Application no: **3/2021/0822**

Address: **Stan-Nor 10 Whalley Road Langho BB6 8EJ**

Proposal: **Proposed dropped kerb for vehicle access.**

Dropped Kerb

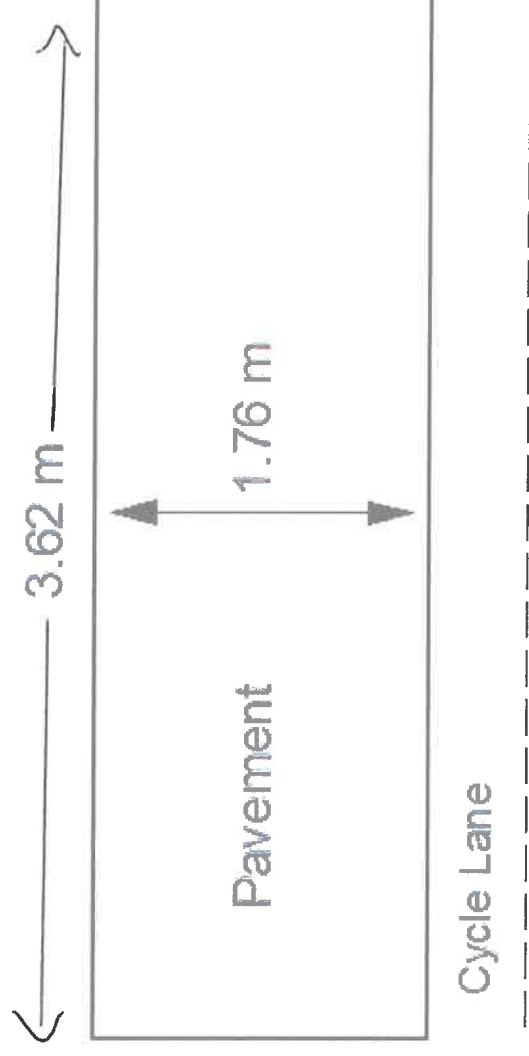
The LHA have reviewed the supporting documents and understands that the site access will be 3.62m wide which complies with the LHAs guidance.

The depth of the driveway, which is stated in the Application Form dated 9th August 2021, will be 6.9m which will mean that a vehicle is able to park on the driveway.

The driveway will also have a turning facility to enable vehicles to emerge onto the classified public highway in a forward gear which the LHA require.

1. No part of the development hereby permitted shall be occupied until such time as the access arrangements shown on drawing titled "Photo and Plans" have been implemented in full.

2. The gradient of the access drive shall not exceed 1:12 for the first 5 metres behind the Highway boundary.

3. No part of the development hereby permitted shall be occupied until such time as vehicular visibility splays of 2 metres by 43 metres have been provided at the site access. These shall thereafter be permanently maintained with nothing within those splays higher than 1 metres above the level of the adjacent footway/verge/highway.

4. No part of the development hereby permitted shall be occupied until such time as 2.0 metre by 2.0 metre pedestrian visibility splays have been provided on the highway boundary on both sides of the access with nothing within those splays higher than 1 metres above the level of the adjacent footway/verge/highway and, once provided, shall be so maintained in perpetuity.
